March 2, 2021

Subject: Response to Review Comments  
Solace Apartment Complex  
Powers Boulevard and Galley Road  
Colorado Springs, Colorado  
CTLT Project Nos CS19163.000-105

SOLACE APARTMENTS – FILING NO. 1		POND A DETAILS	
SHEET	19	OF	32
JOB NO.	25174.00

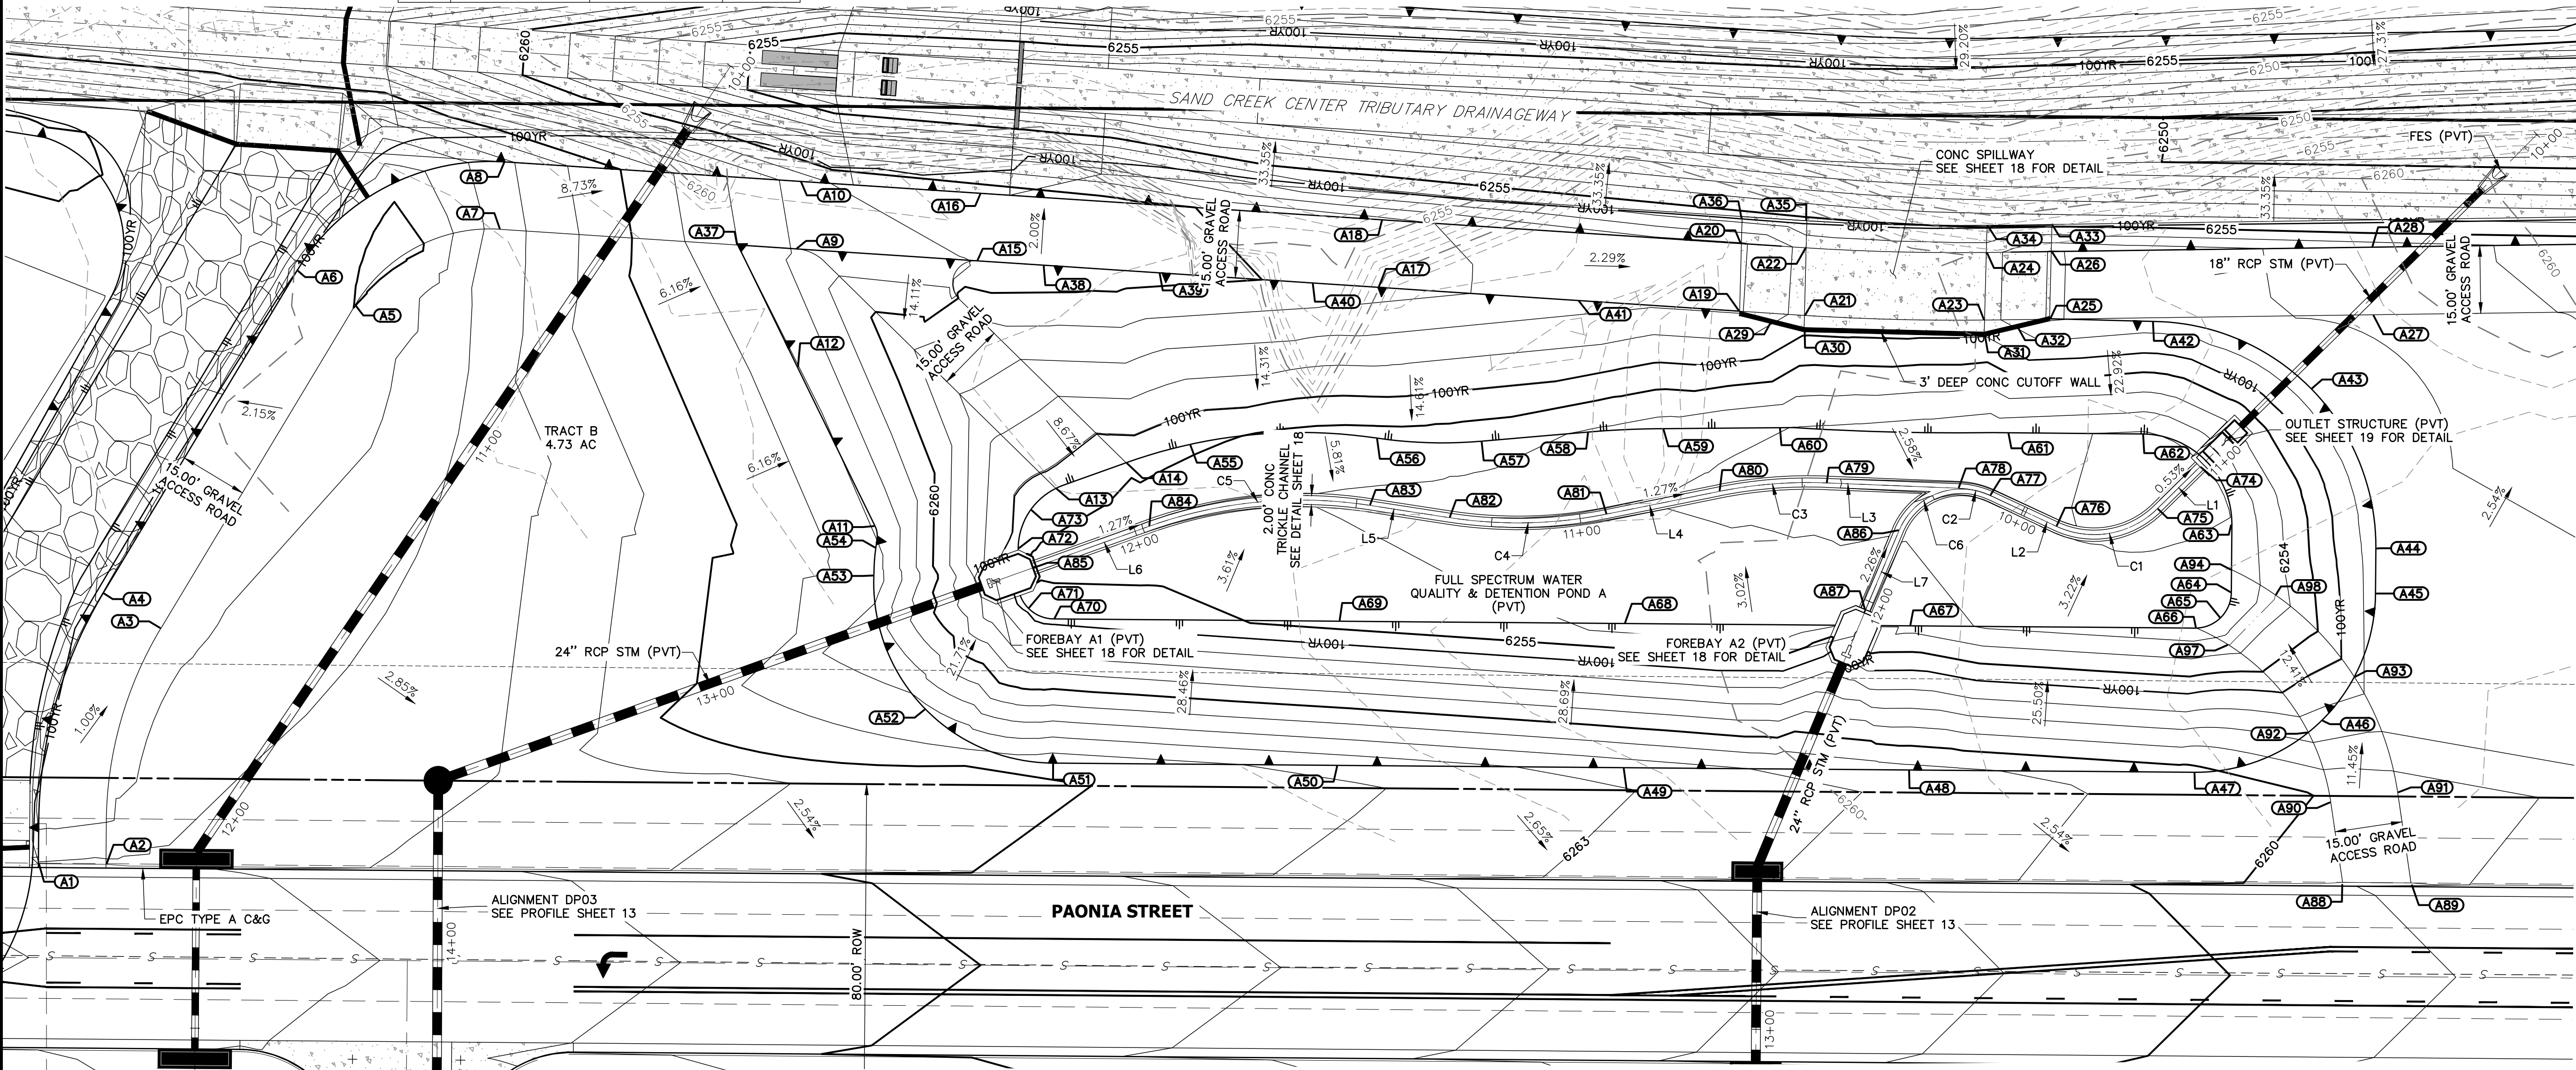
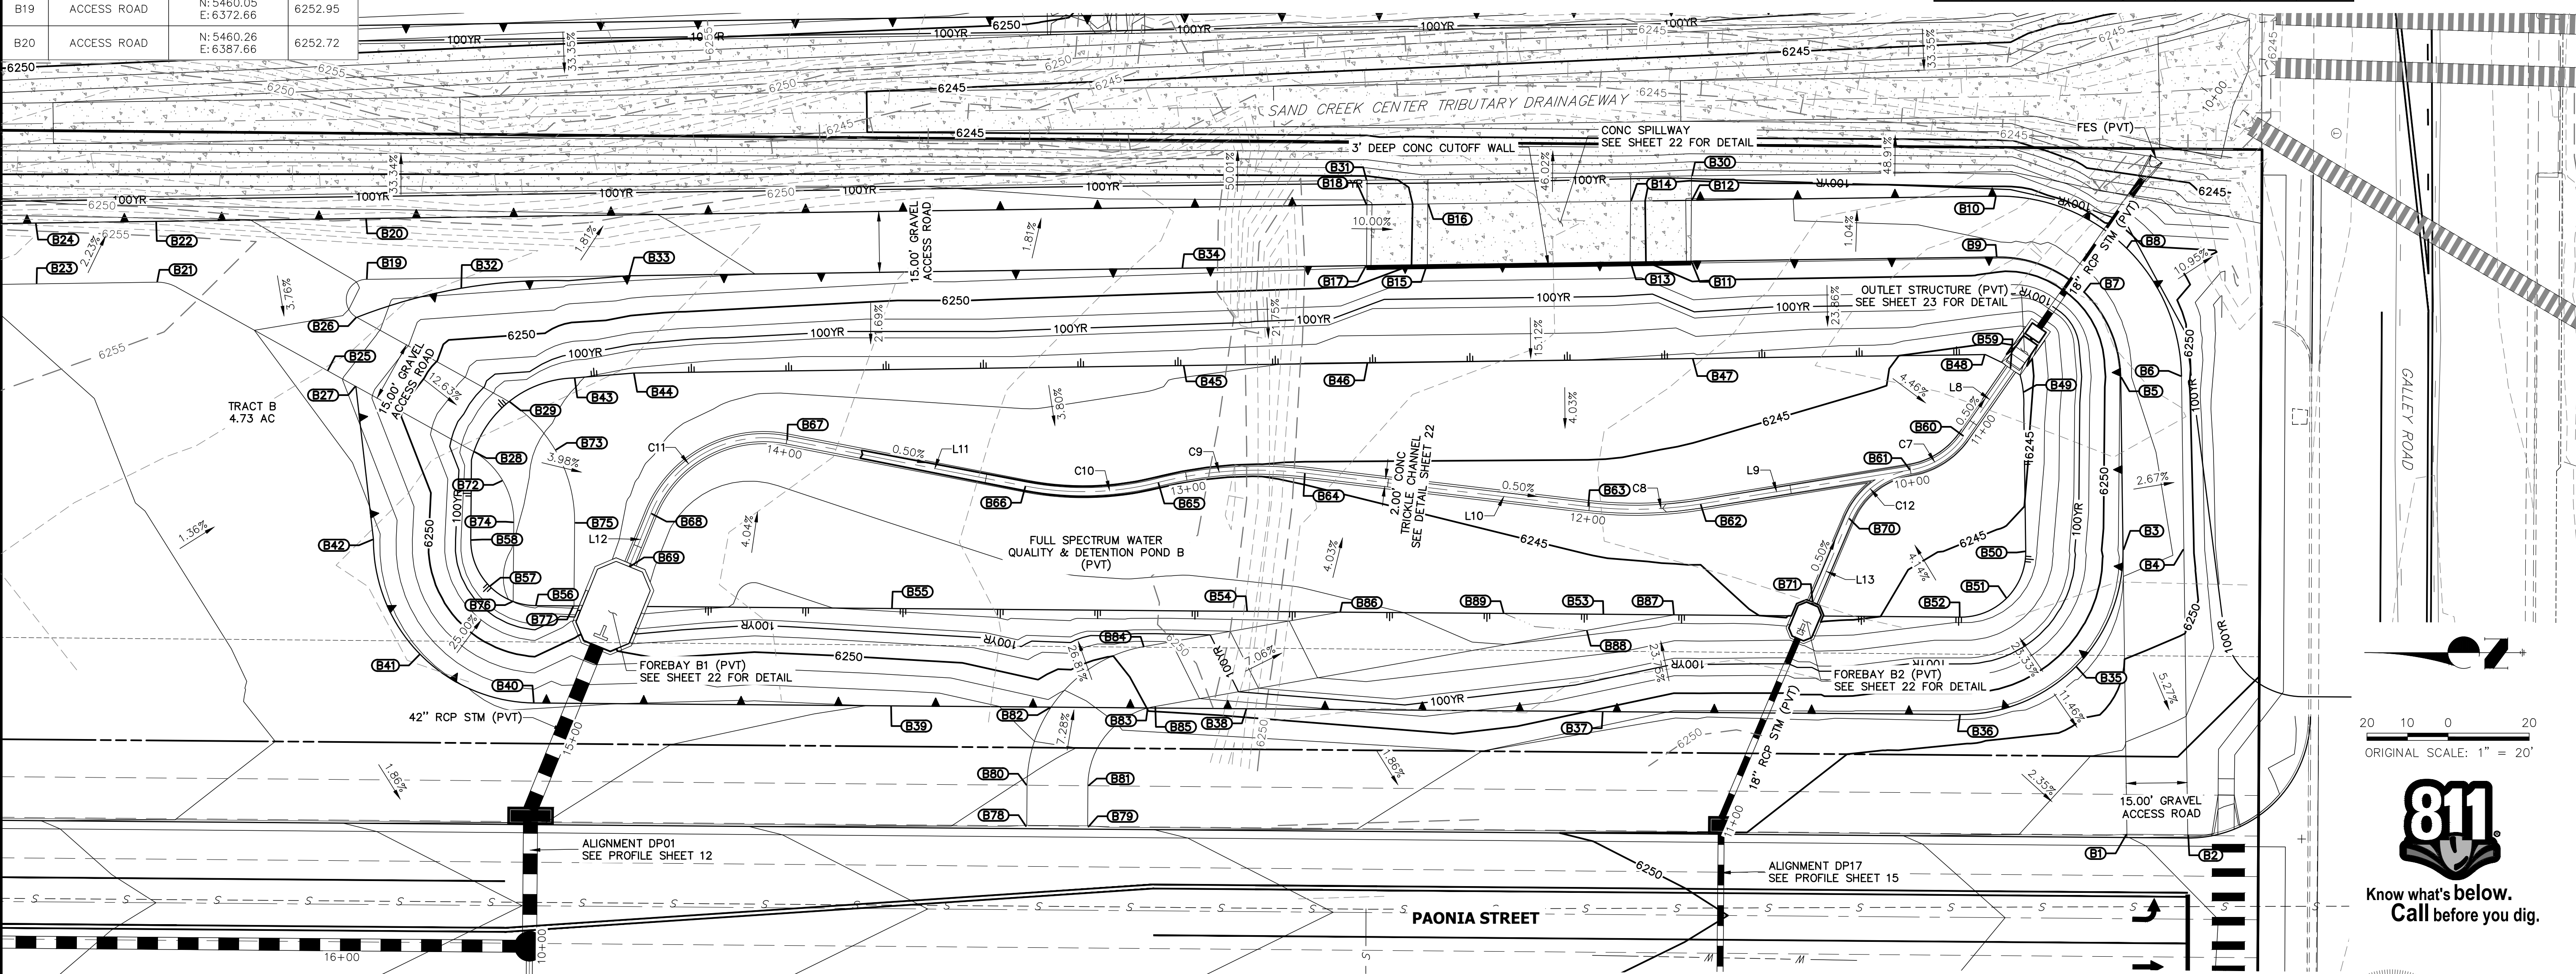
Comment: Per the submitted construction documents the embankments appear to be larger than 5 ft in height. Please coordinate the project civil engineer and revise your analysis accordingly.

Response: The updated construction plans indicate embankment heights of about 5-feet and cuts below the embankments of about 4 feet to create the overall pond volume. The proposed embankment slopes are flatter than 3:1 (horizontal to vertical). We believe this layout is consistent with recommendations made in our reports.
